# CITY OF ALBUQUERQUE

May 19, 2017

RE: **ABQ Ride Daytona Transit Facility**  
**Conceptual Grading and Drainage Plan**  
**Engineer's Stamp Date: 5/18/17**  
**Hydrology File: J09D025**

DESIGN REVIEW COMMITTEE		CITY ENGINEER APPROVAL		MO./DAY/YR.	
City Project No. COA 5658.05		Zone Map No. J-09-Z		Sheet 1 of 2

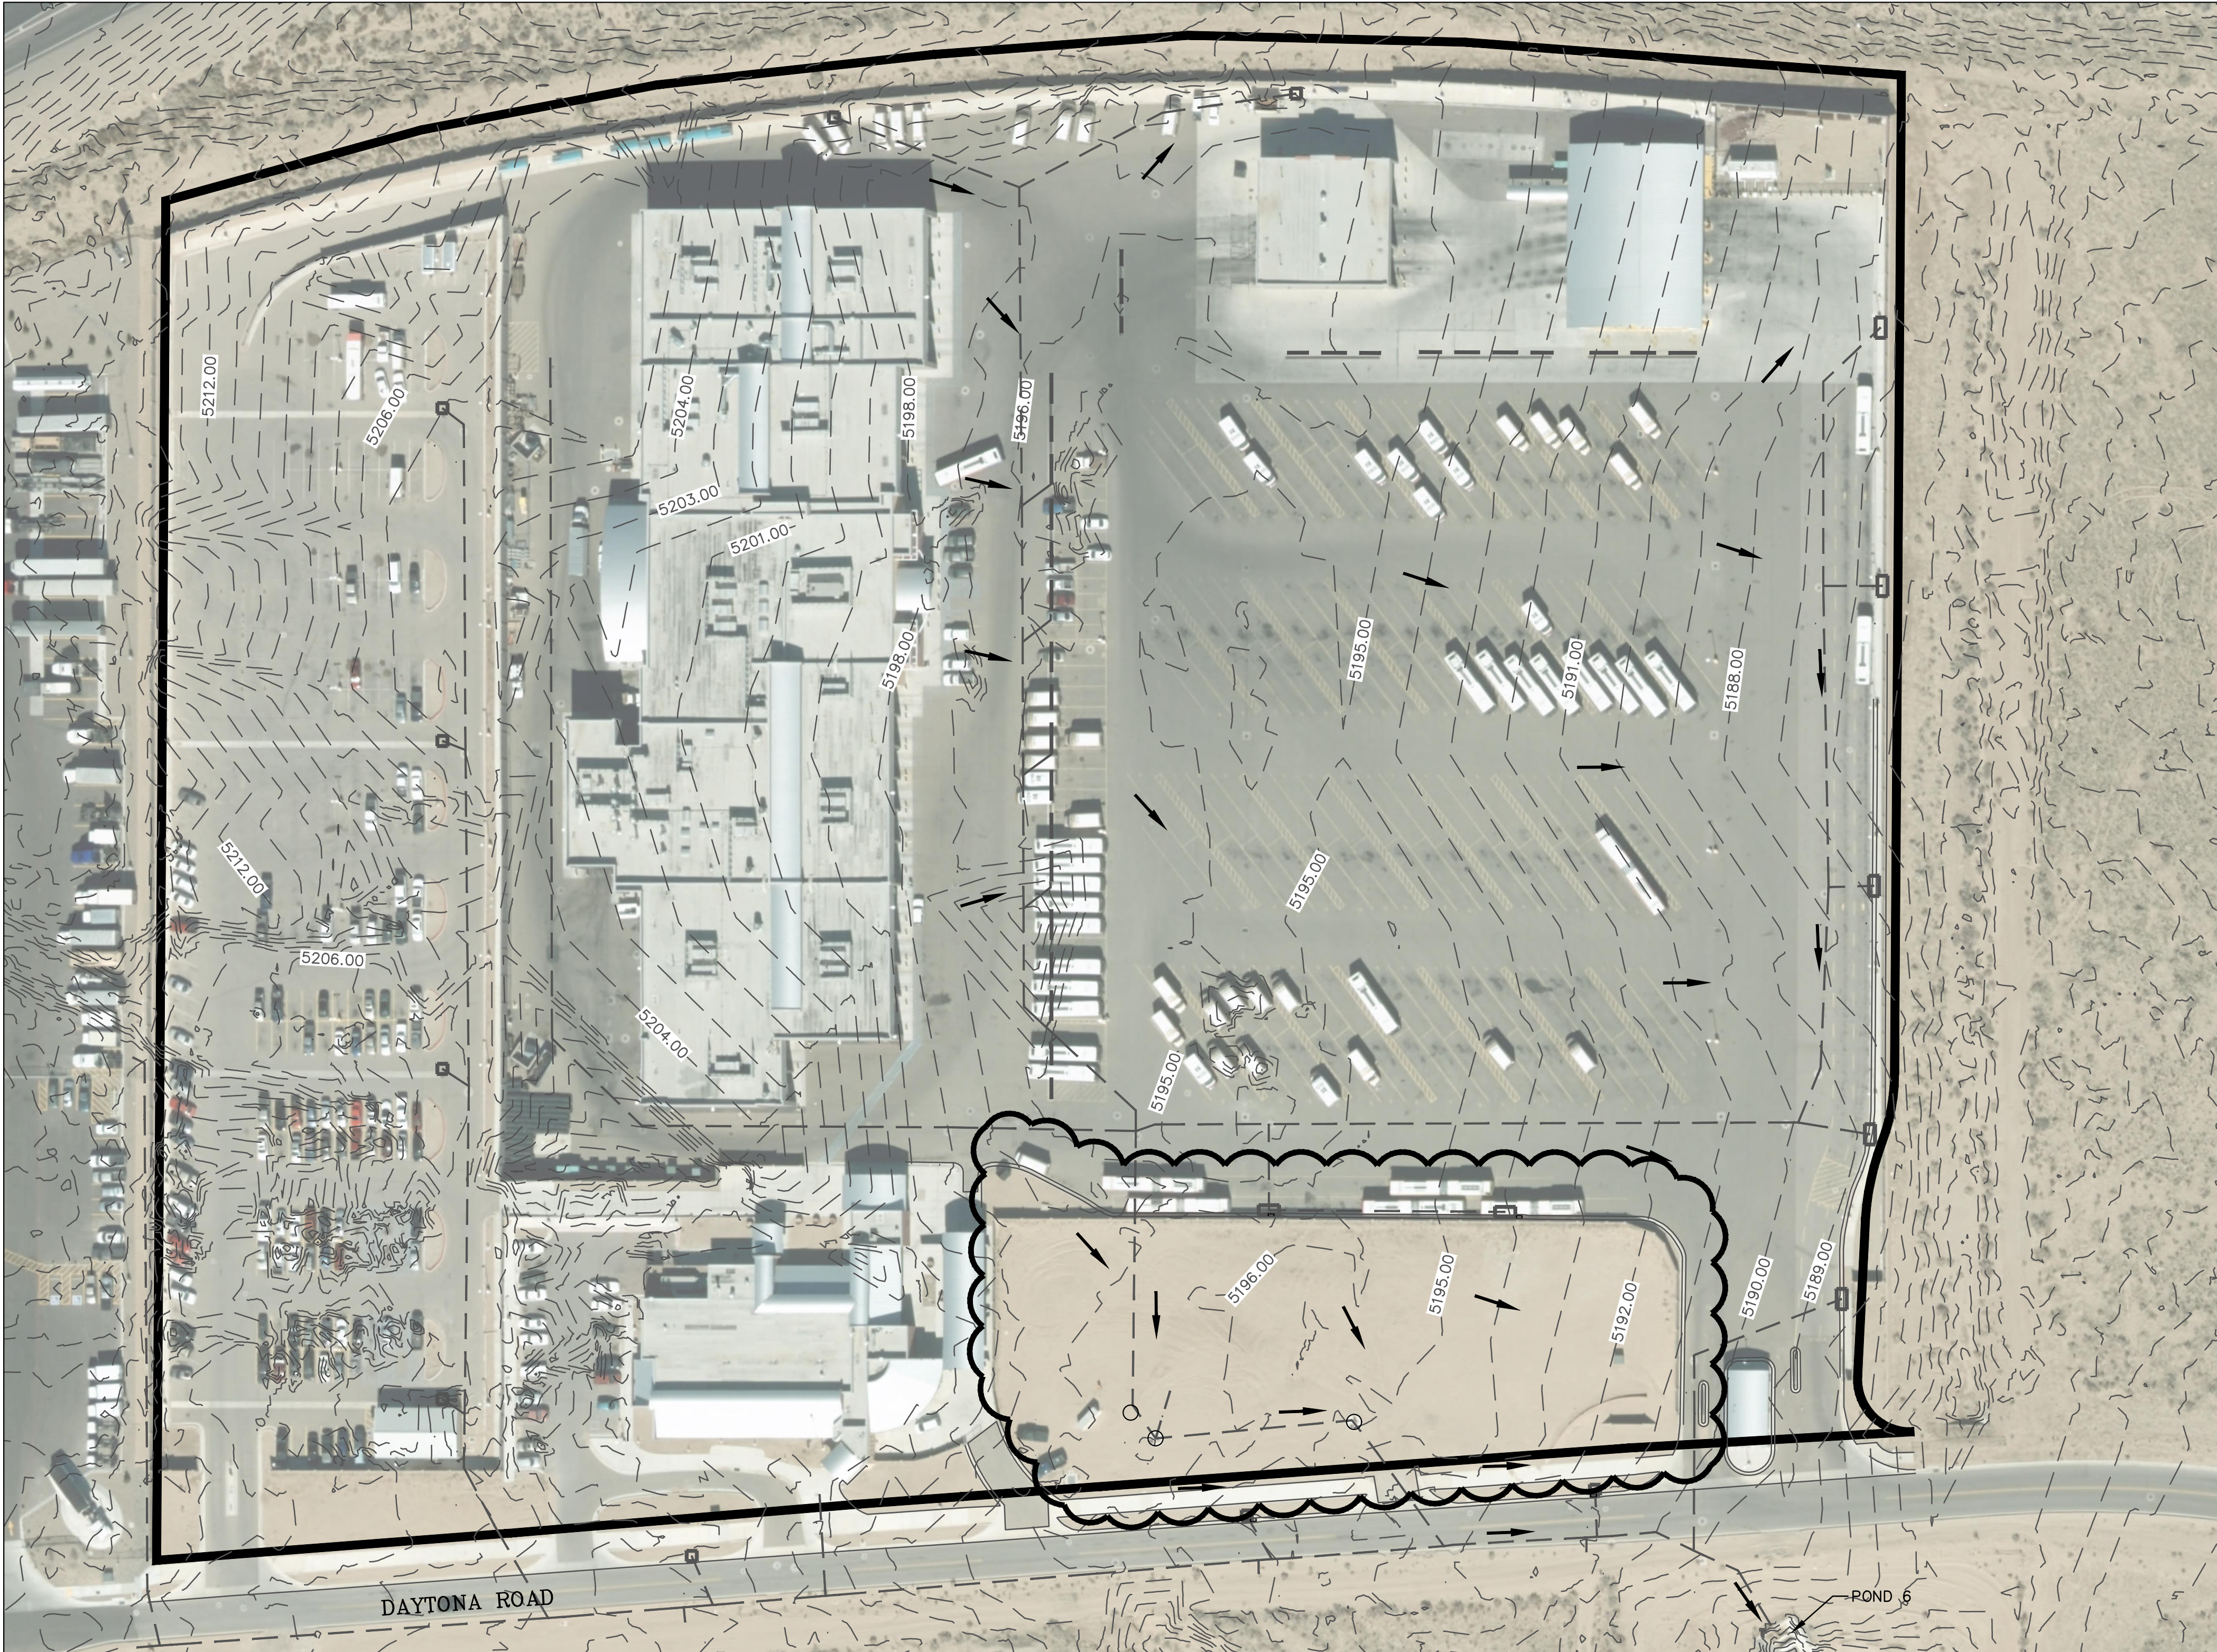
1. The storm water quality volume is not being retained on-site because this site is permitted under an industrial discharge permit requiring flows from the parking areas to be routed through the oil/water separators. The drainage narrative needs to be updated to reflect that the drainage from the new impervious parking lot is required to comply with the site's SWPPP and cannot be retained and infiltrated.
2. The depressed landscaping areas that will retain non-contaminated flows from the sidewalk areas need to be depressed with 5:1 side slopes. Additional notes regarding storm water quality swales are attached.
3. Provide invert, slope and capacity data to ensure the new storm drain will function as proposed.
4. Increase the density of existing and proposed contour labels.
